Please ask for: Mrs D Johnson
Email: daun.johnson@arun.gov.uk
Telephone: 01903 737762
Our Ref: R/102/20/PL
Your Ref:
Date: 15th June 2020

Application for Planning Permission

Development: 1 No. detached 5-bedroom house with attached single storey double garage & carport.
Location: Land North Of Springfield House Cross Road Rustington BN16 2ST

Proposed Entrance Elevation

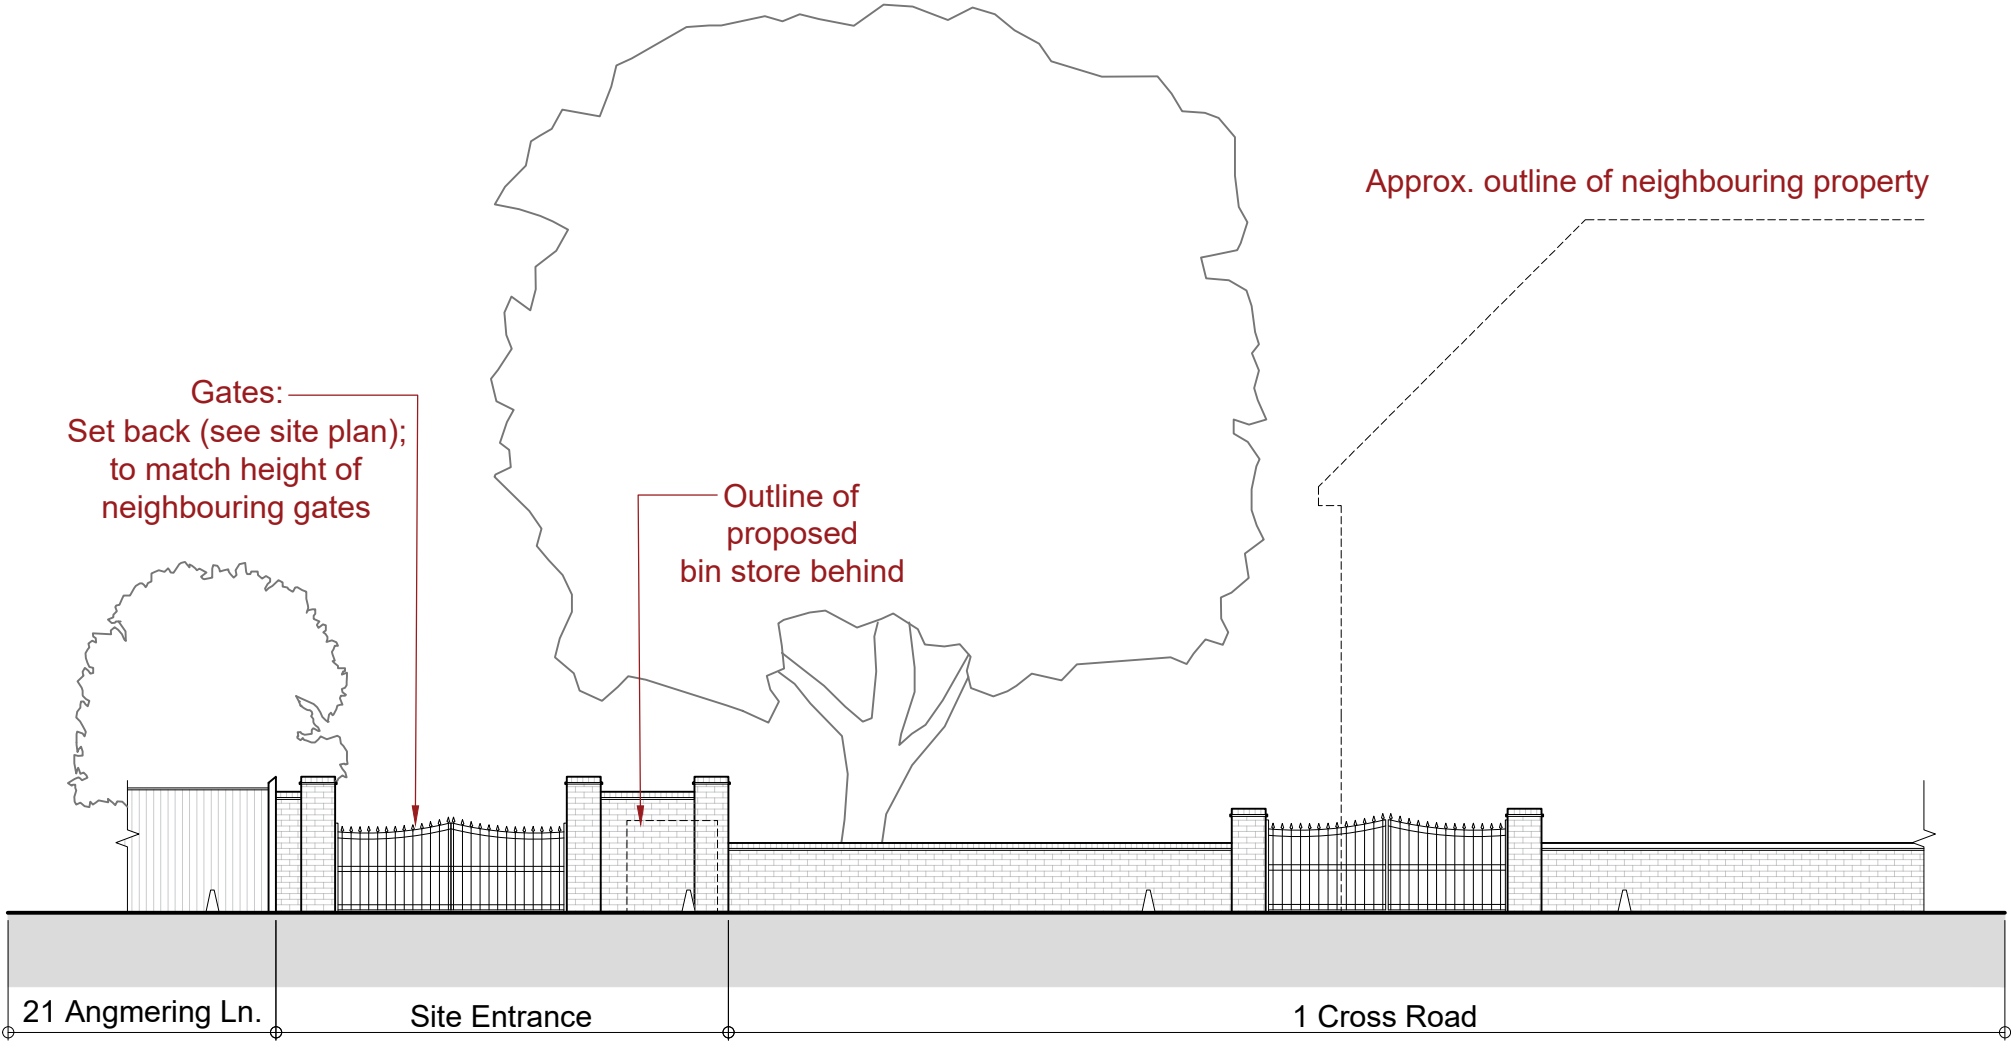
Please provide an elevation for the entrance gate.
